Light Valley Solar

The Applicant's Response to Relevant Representations (Part 1)

September 2026

Planning Inspectorate Reference: EN0110012
The Infrastructure Planning (Examination Procedure) Rules 2010
Rules 8(1)(c)

Drawing Number
EN0110012/APP/LVS/06.02.06.12.02

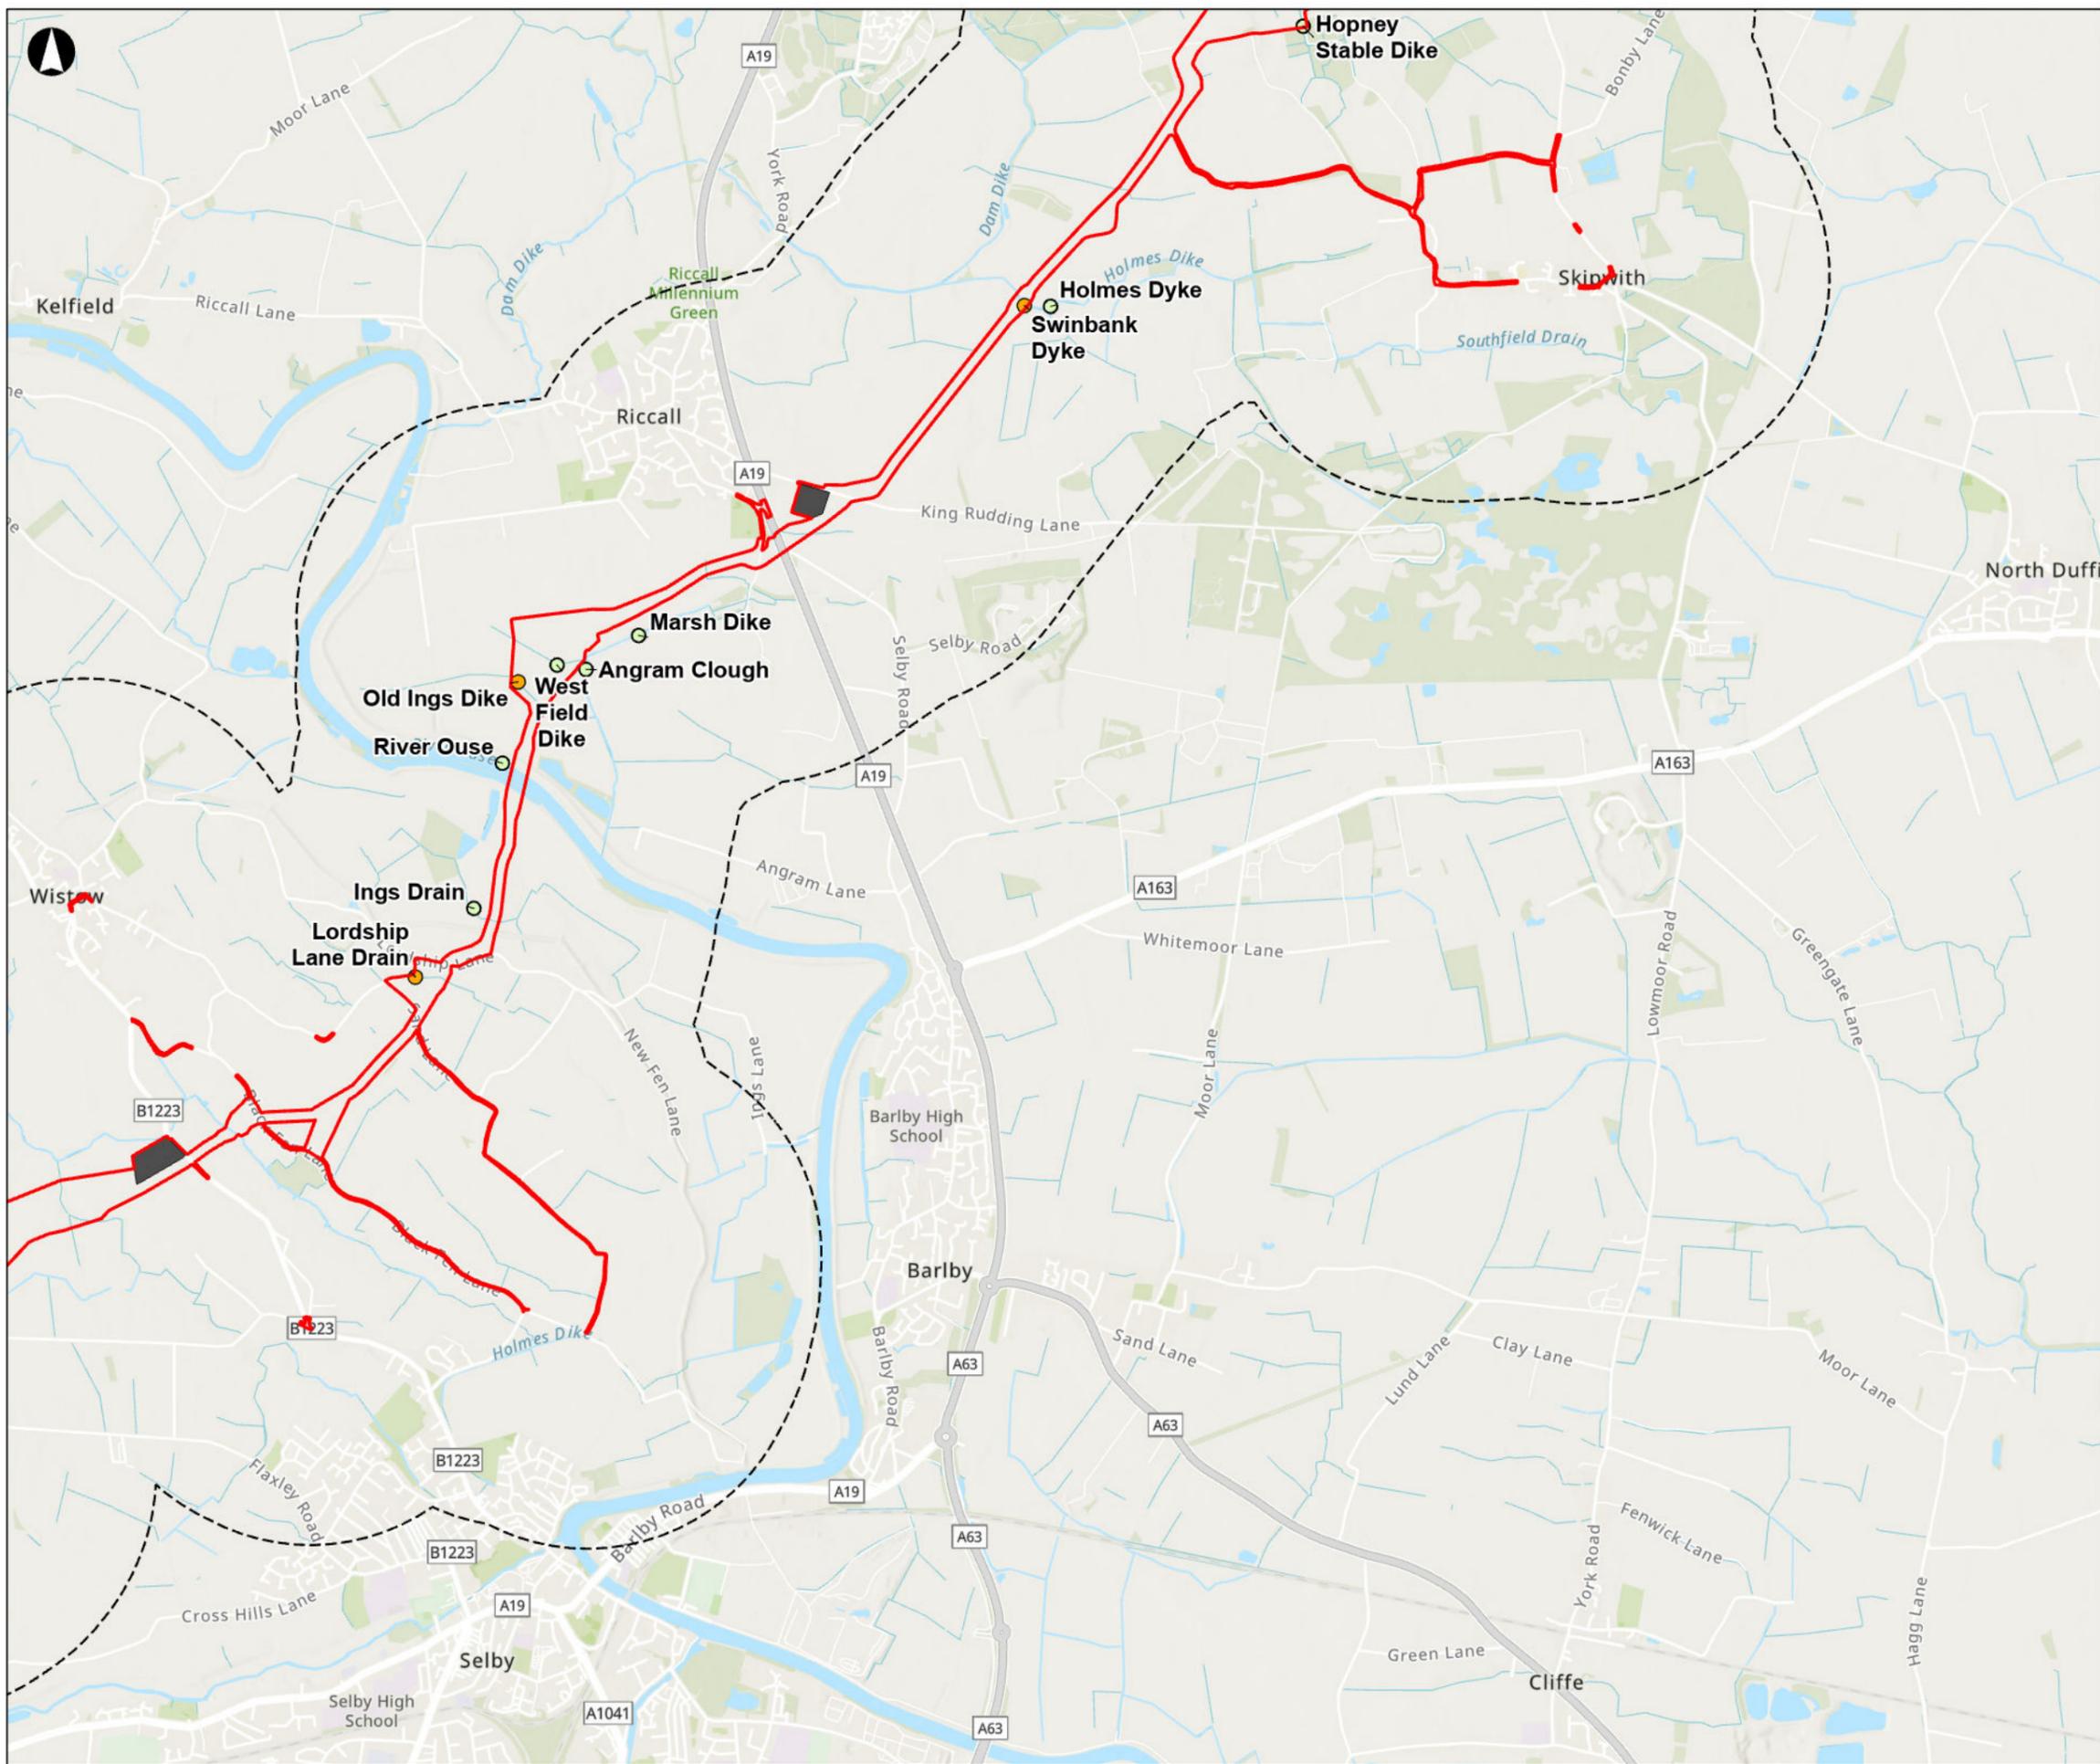
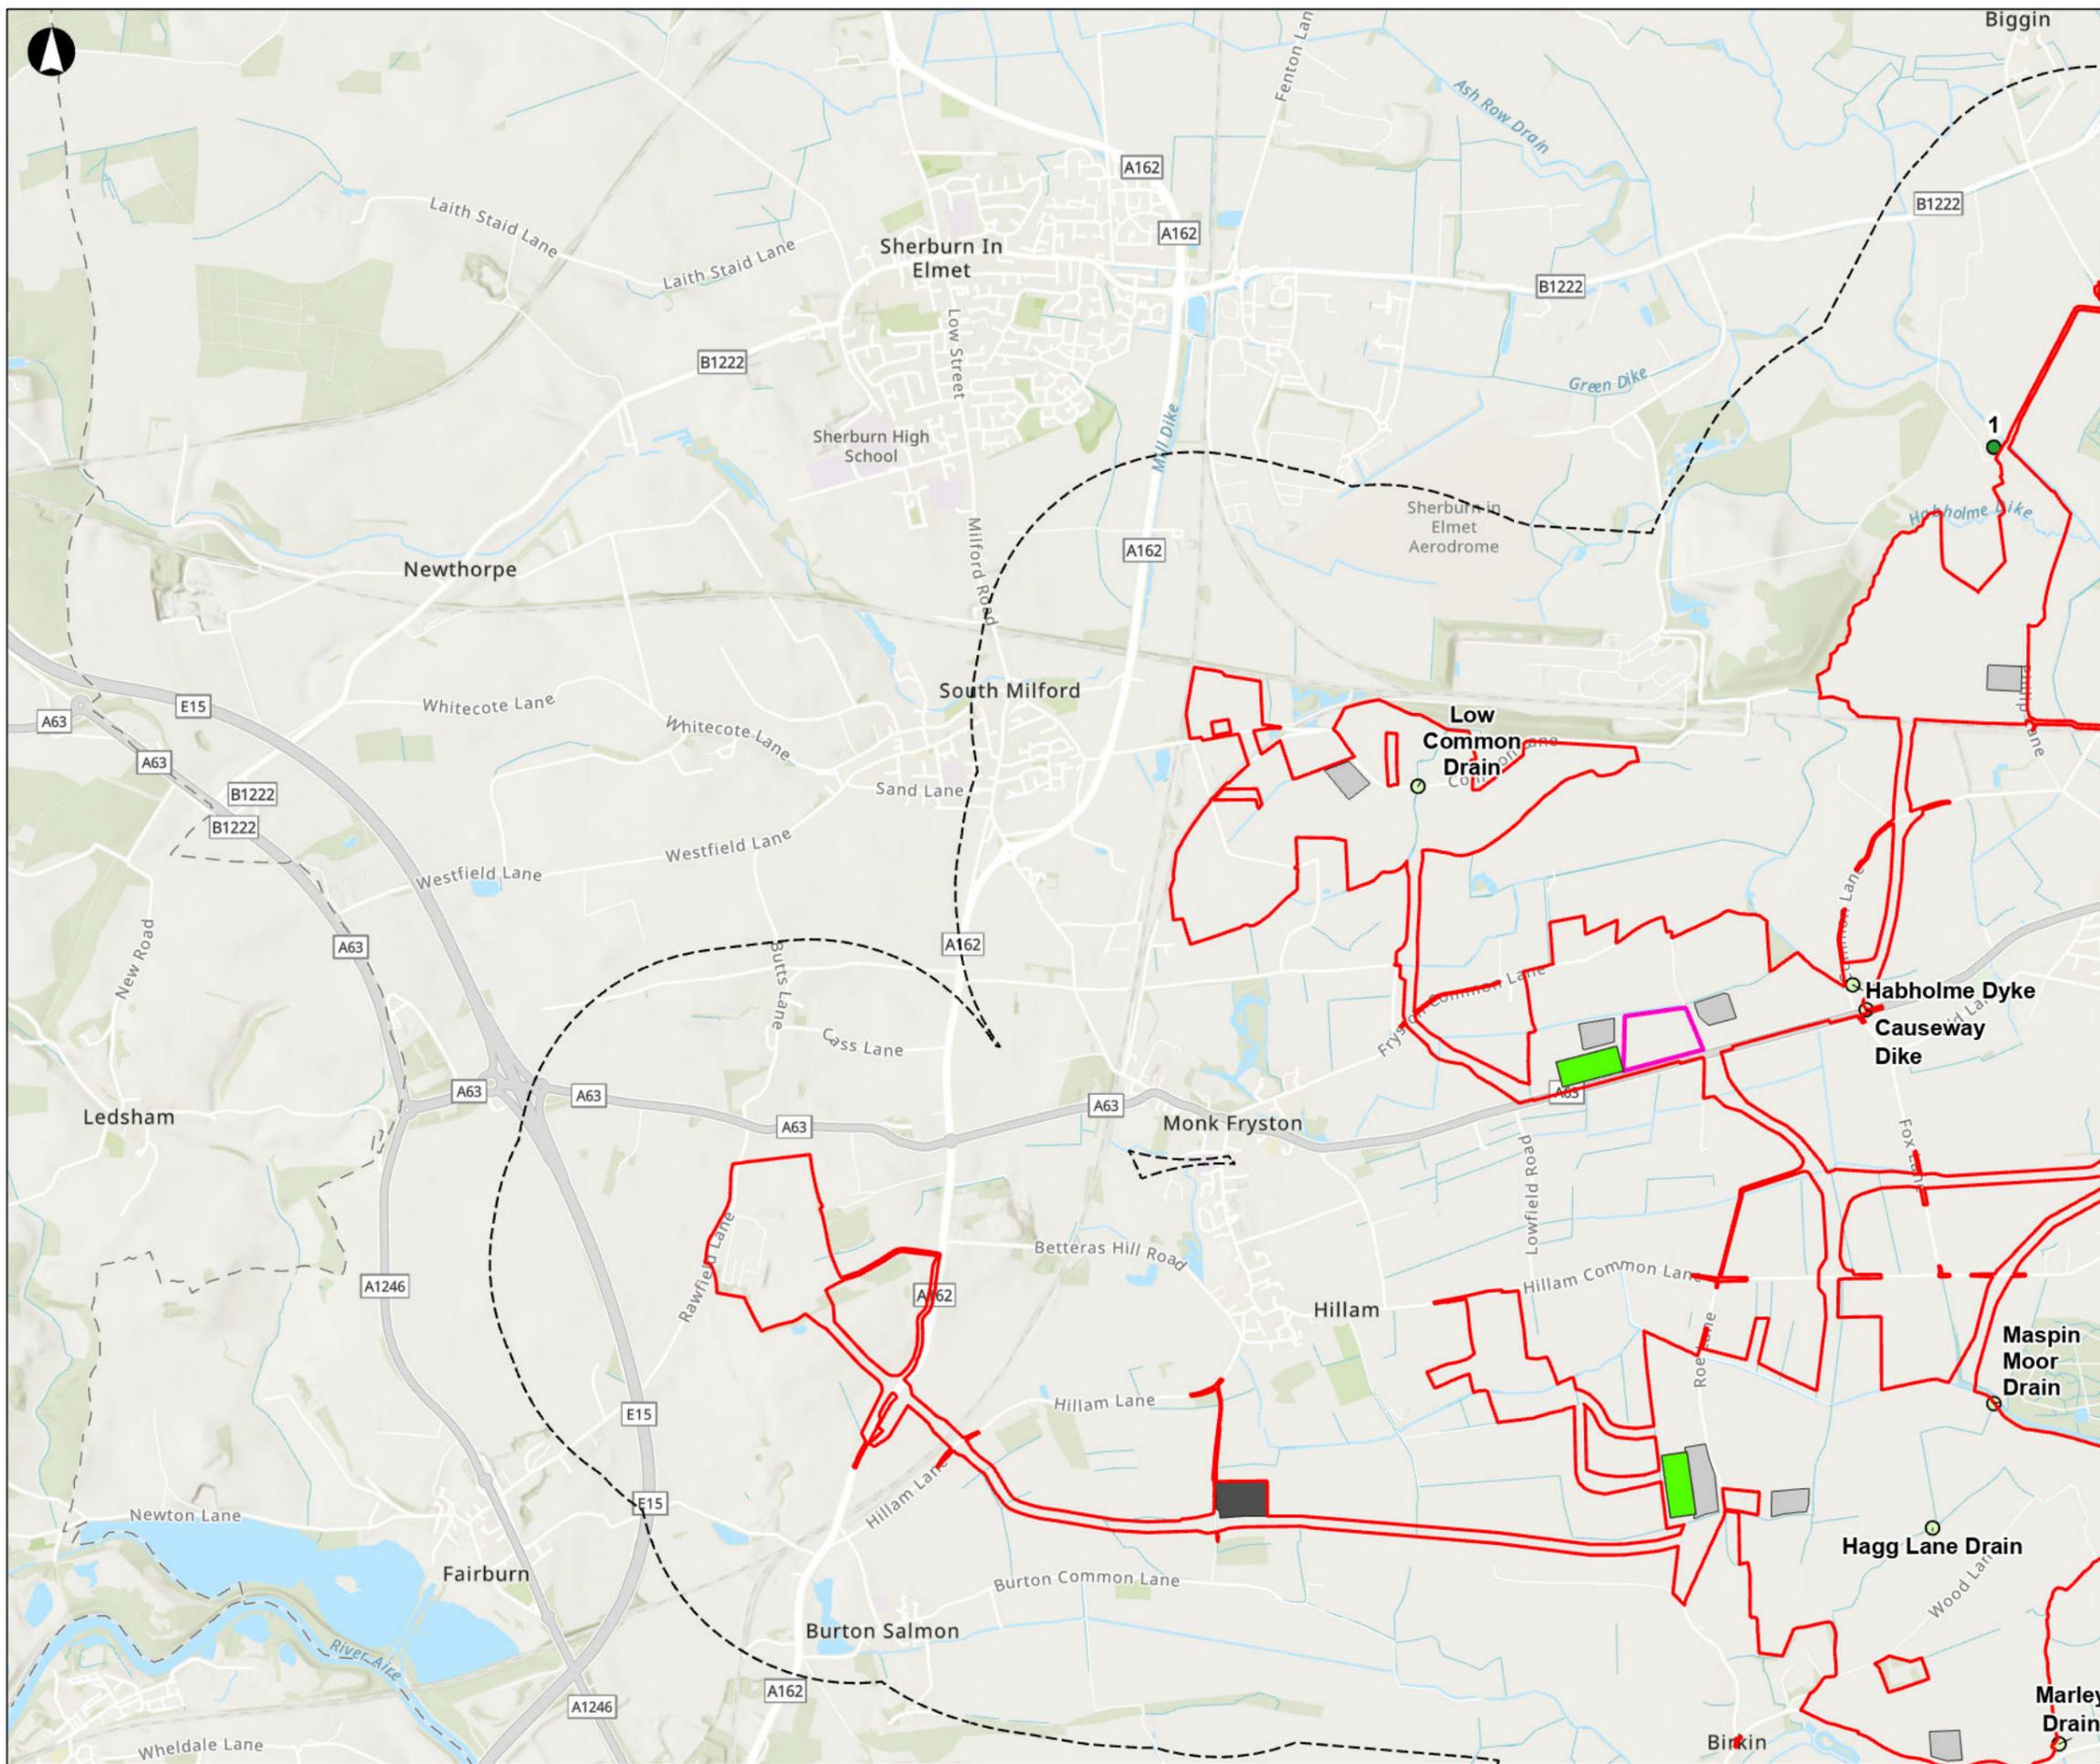
ID	Theme	Issue	Comment			Applicant's Response
EA02	Biodiversity and Ecology	Fish eDNA Survey	Appendix 6.5 Fish Habitat Assessment and eDNA Survey (Aquatics Report) [APP-155], Sections 3.2.20 to 3.2.26, Table 2-2	Issue:	The fish habitat assessment concludes that the Hagg Lane Drain and Mearley Drain are unsuitable for fish and have therefore been scoped out of the eDNA survey. It has not been clearly demonstrated that this is an acceptable approach.	eDNA sampling was targeted at watercourse crossings where impacts could occur, as agreed during consultation with the EA (04 March 2025). Mearley Drain is not crossed by the Proposed Development and impacts will be avoided through a 10 m buffer within Solar Development Site 4. Hagg Lane Drain is crossed by the lower voltage 33kV cable alignment; however, it is envisaged this watercourse will be crossed using an existing crossing. As no impact pathways to these watercourses are anticipated, the level of baseline data collection and consideration of the

Impact:	It is possible that fish could be present in these watercourses and could be detrimentally impacted.	
				Solution:	The Hagg Lane Drain and Mearley Drain should both be

included in the fish eDNA survey, unless further sufficient evidence can be presented that would support the initial findings of the fish habitat assessment.	desk study position is proportionate to inform the EIA of impacts to these watercourses. The EA will be provided with grid references for each survey location.
			Additional comments:	Where there is an insufficient baseline to inform the Environmental Impact Assessment (EIA), impact-pathways to receptors may not be fully assessed. Whilst we agree that waterbodies that lack water are unsuitable for fish, we do not agree with the conclusion that the Hagg Lane Drain and Mearley Drain are unlikely to support fish due to poor habitat. Both of these waterbodies have hydrological connectivity with the River Aire. While we acknowledge that fish passage for European eel may be hindered by the pumping station on the Mearley Drain, the eDNA results for Selby Dam demonstrate that the presence of a pumping station does not necessarily preclude European eel. It would be useful if Table 2-2 could be updated to include grid references for each survey location. The provision of a map showing the locations would also be welcomed. Both would assist the reader in understanding where surveys have been undertaken in relation to the draft Order Limits.		A figure showing survey locations in relation to the draft Order Limits and project components is already provided as ES Volume 2, Figure 6.12: Fish Habitat Assessment, EA Monitoring Locations and eDNA Survey Locations [APP-083] .
